Tel: 01903 737756
Email: planning@arun.gov.uk
www.arun.gov.uk/planning
Please ask for: Ms Ella Summerfield
Email: ella.summerfield@terraquest.co.uk
Telephone: 0121 2341390
Our Ref: EP/68/26/HH
Your Ref:
Date: 14th July 2026

Application for Planning Permission for Works or Extension to a Dwelling

Development: Two storey front extension. New windows. New cladding to the first floor.
Location: 8 Tamarisk Way East Preston BN16 2TF

Site Location Plan

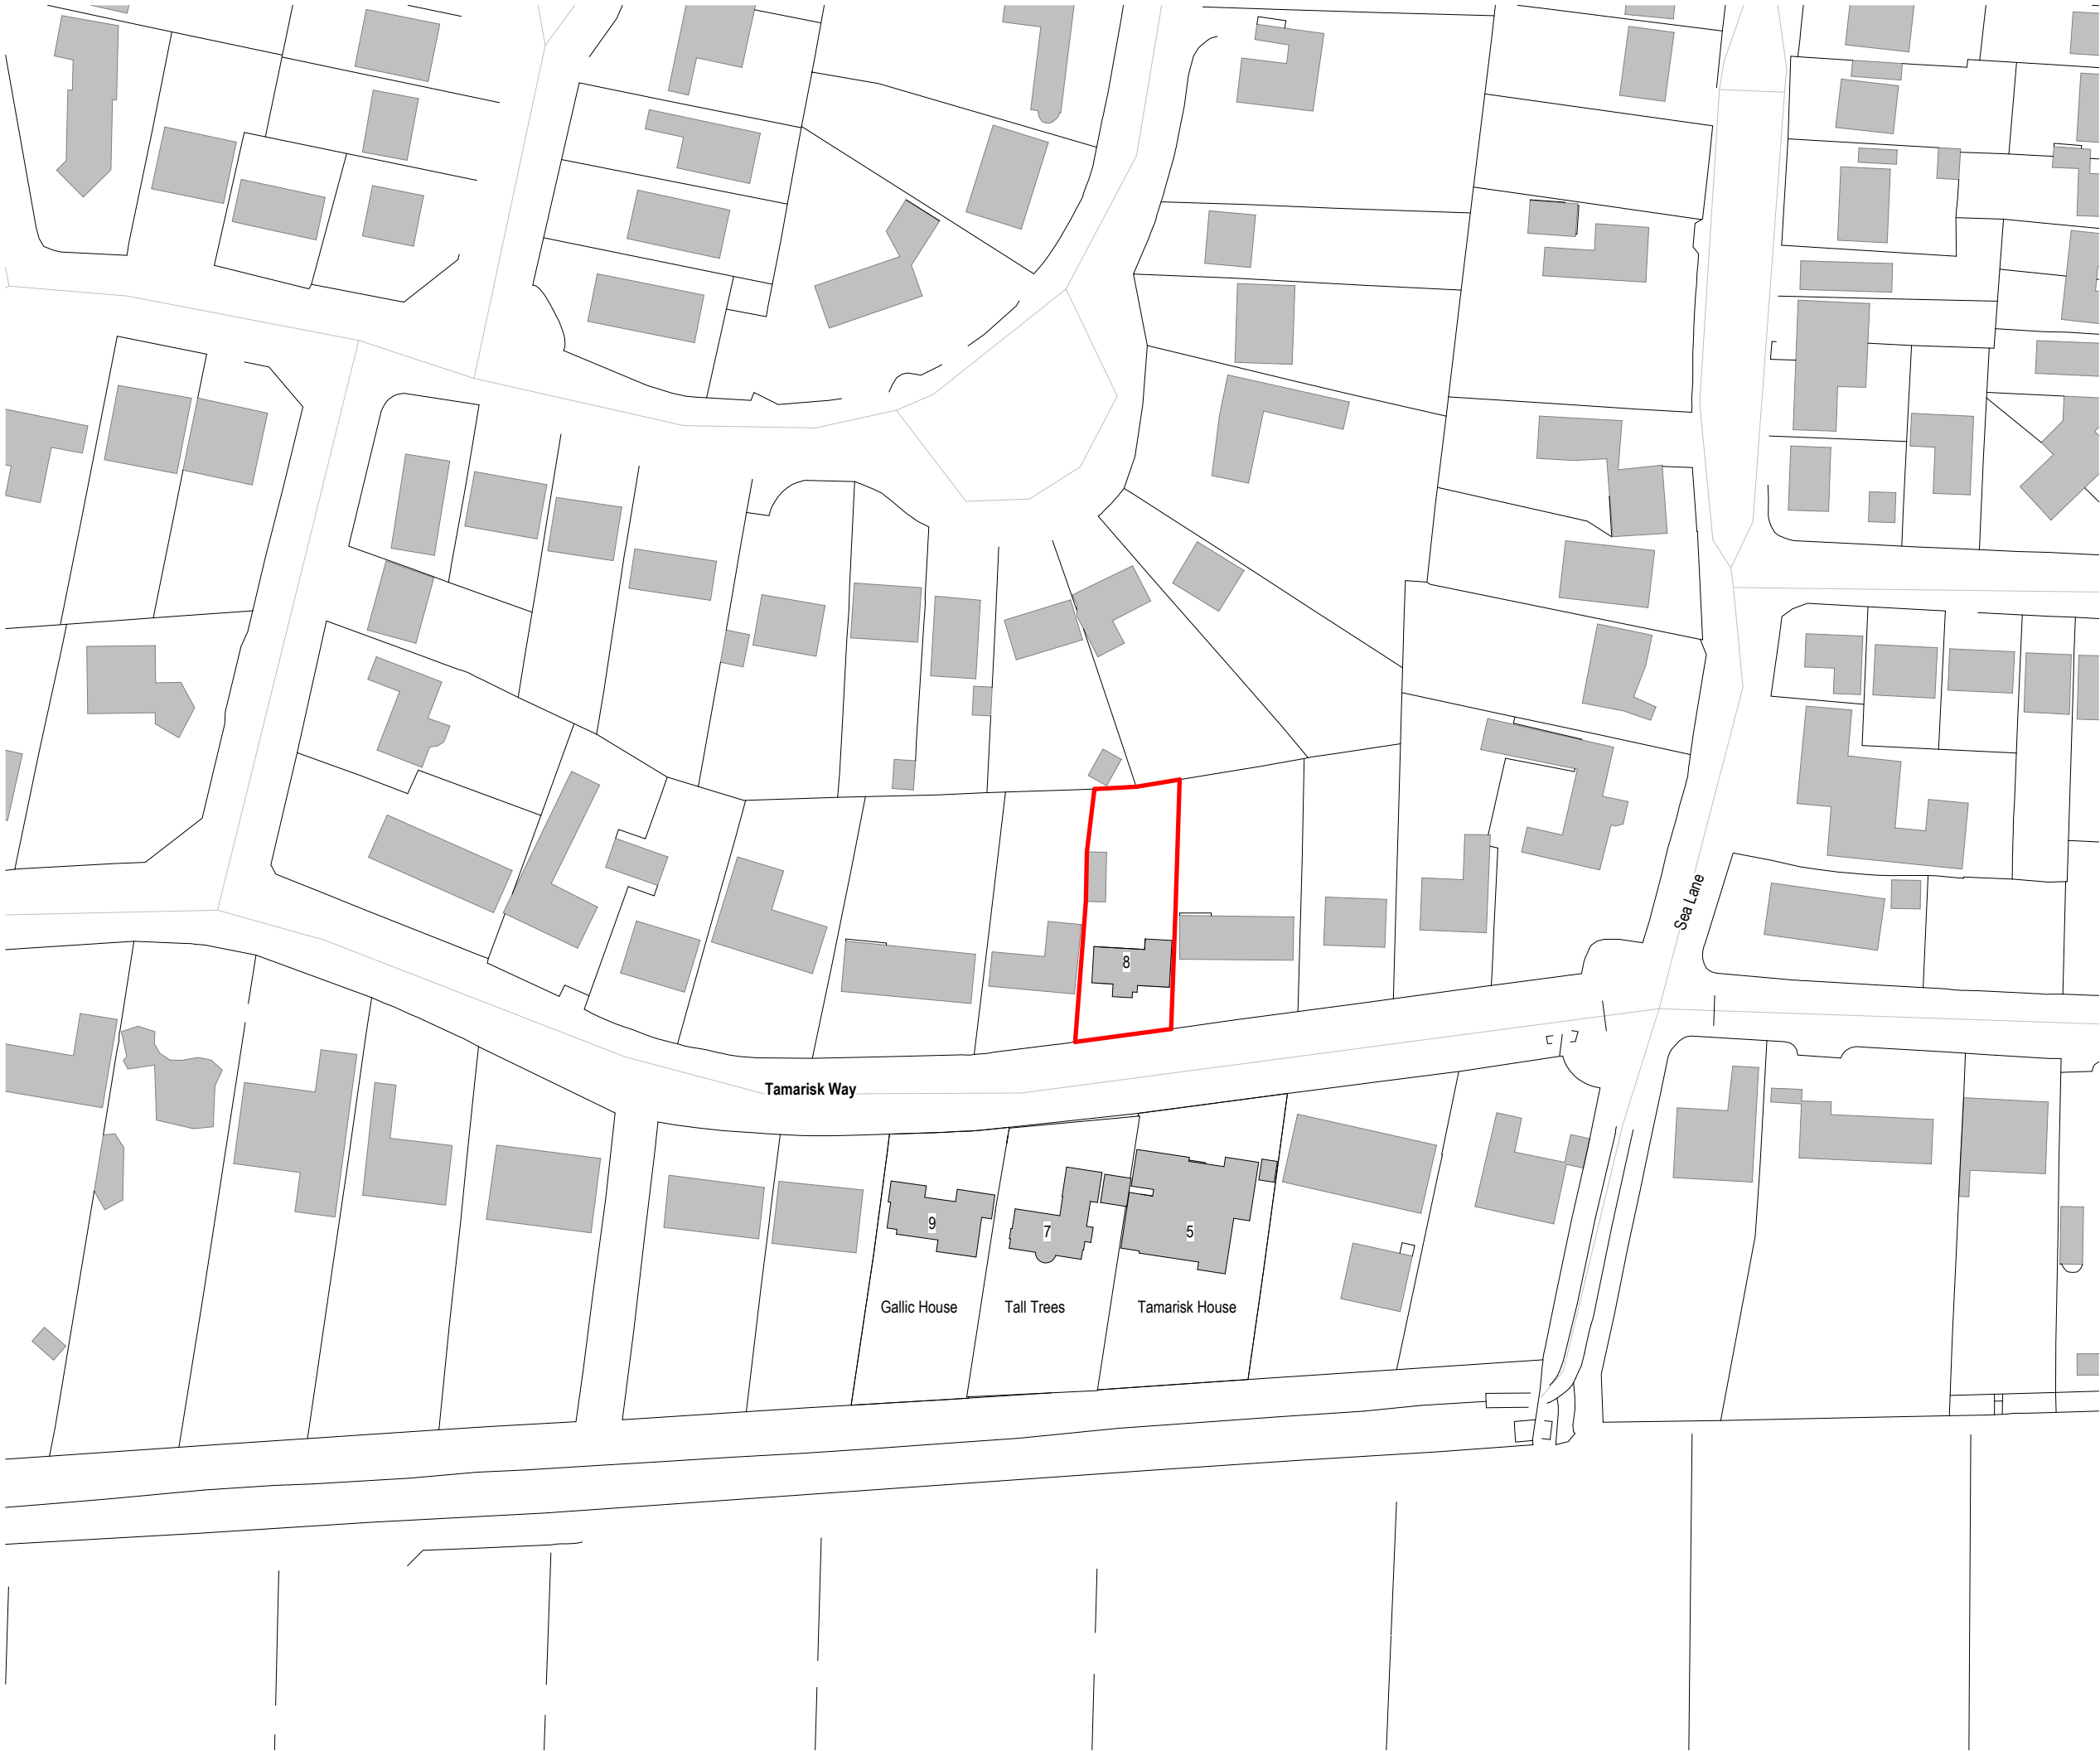
The block plan scale can be no higher than 1:500, the proposed block plan has a 1:1250 scale and scale bar, please amend.

Block plans require dimensions to be provided from the proposed extension to the site boundary, please amend.
